Application No: EP/55/22/PL

Recommendation Report for Planning Permission

LOCATION: 4 Beechlands Cottages
Beechlands Close
East Preston
BN16 1JT

PROPOSAL: Variation of condition imposed under EP/41/17/PL relating to condition 2-approved plans.

South Elevation (Front)

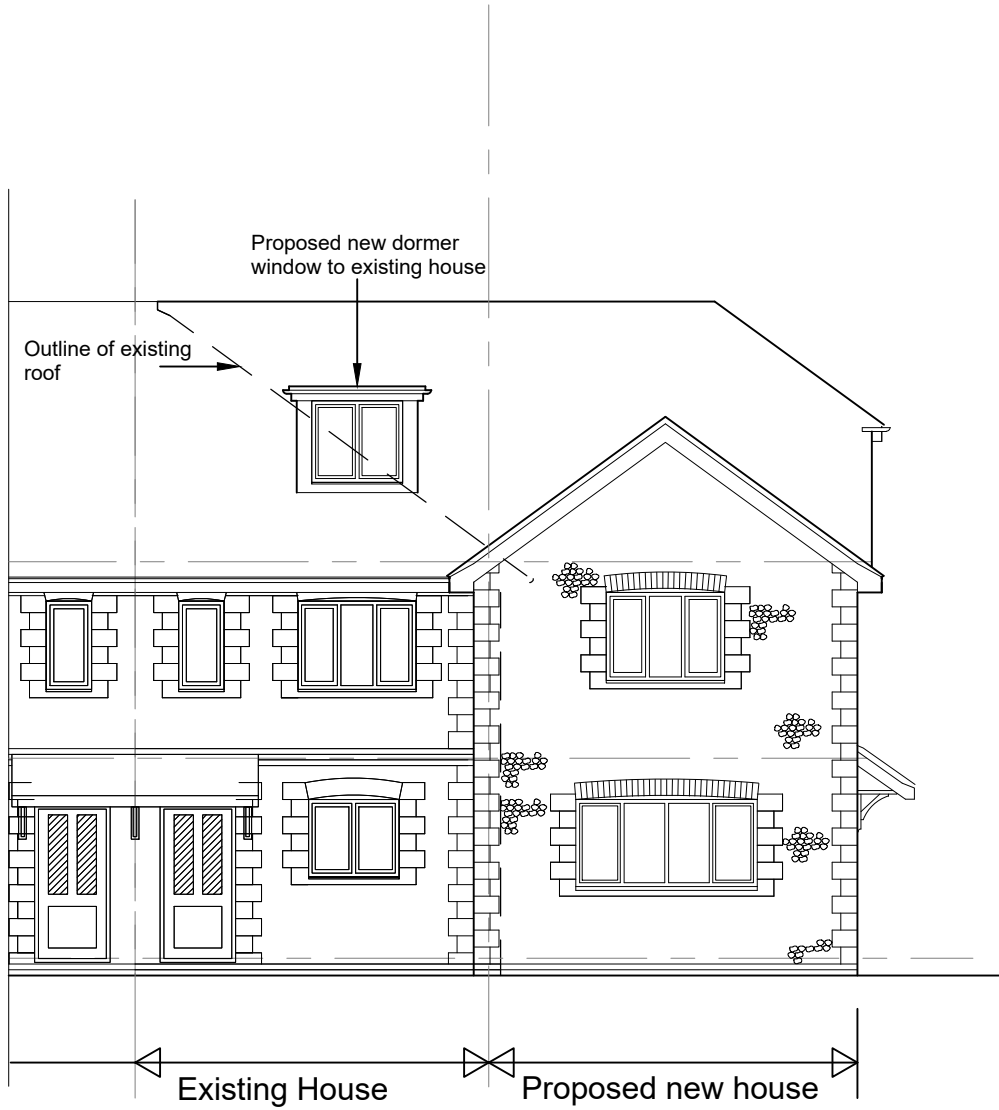
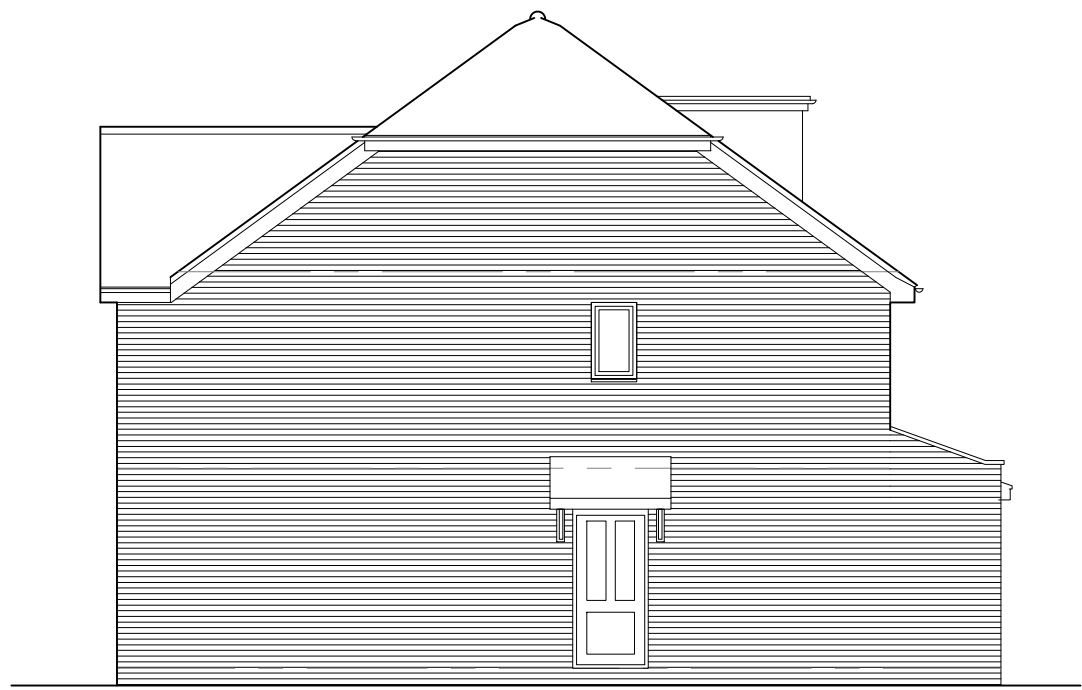
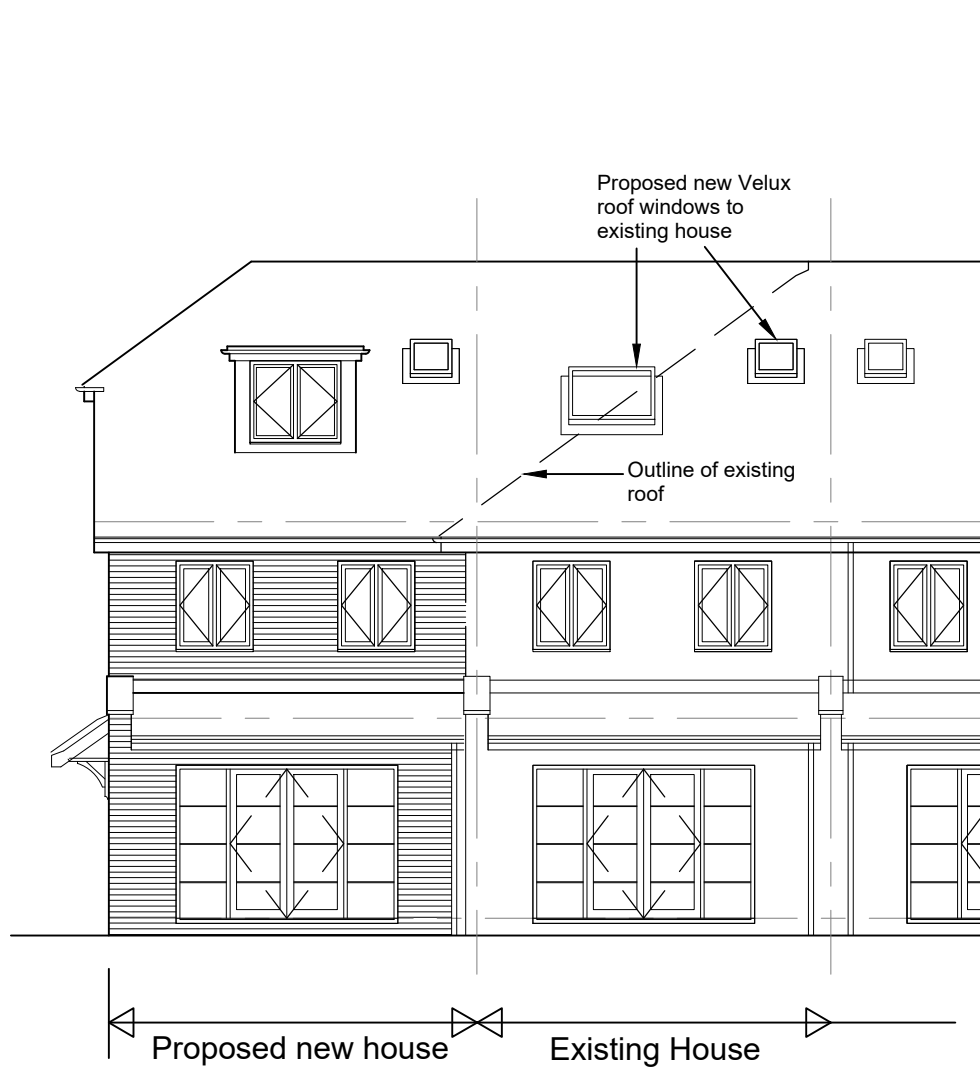
The proposed amendment to the approved plans sought is the simplification of the ground floor layout. An inset bay window to the front of the property, serving the kitchen was proposed in 2017, with an overhanging projection from a bedroom above forming the roof of the bay. It is now proposed to build the ground and first floor in line with one another, this will therefore increase the size of the ground floor by removing the inset bay and positioning an equally sized window in the external wall. The proposed increase in floor area is approx. 2 sqm.

The proposed additional built form at ground-floor level will achieve visual integration as it will be built with materials which match the existing dwellings, namely flint and brick. As only a small increase to the

footprint on the ground-floor is proposed, which sits directly under that of the first floor the building line will be retained, and the extension will sit in line with the approved built form. By reason of its siting and appropriate scale the proposed development will be subservient to the host dwelling.

The alterations will be visible from the street, however the simplification in design will sit comfortably alongside the other dwellings in the terrace as inset bays are not an existing feature, as such the increase to the ground floor will not adversely affect the character of the area.

In terms of overlooking, views will be decreased from the site as the side returns to the bay window are being removed with the amendments. Furthermore, the window effected is to the ground floor and faces over the public realm, as such, no negative impact to privacy from overlooking will occur.

Ground Floor

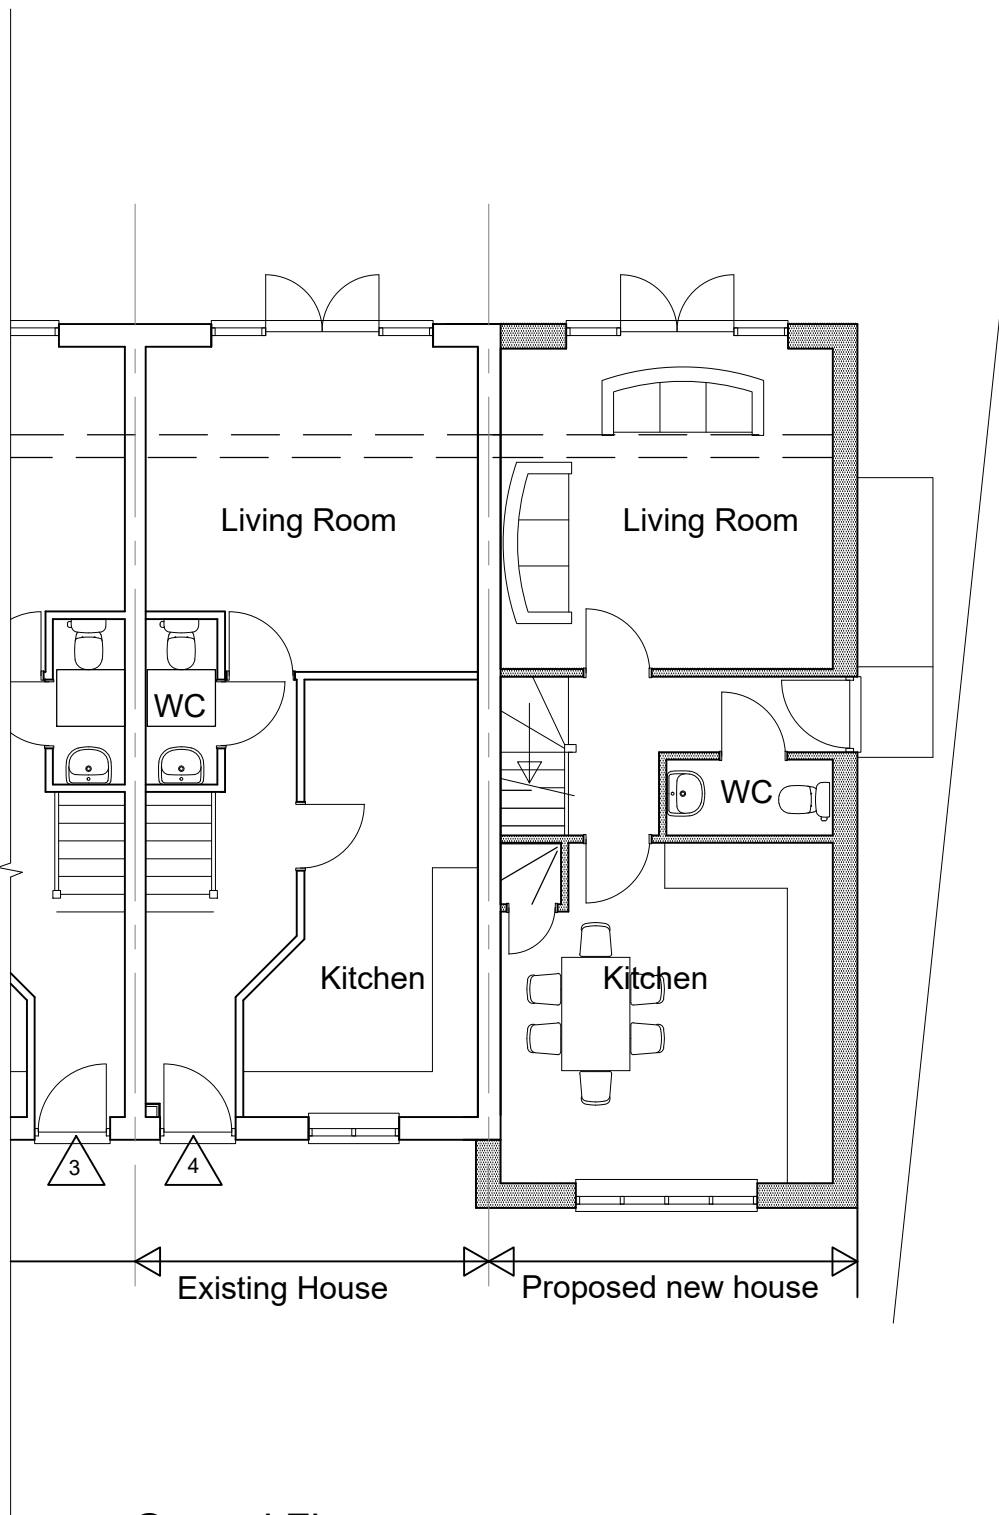
Given that only 2 sqm of additional footprint is proposed to the ground-floor, which does not impact the size of either the first or second floors, and by reason that the proposed development will occur to the front of the property, no negative impact from the proposal being overbearing or overshadowing neighbouring properties will arise.
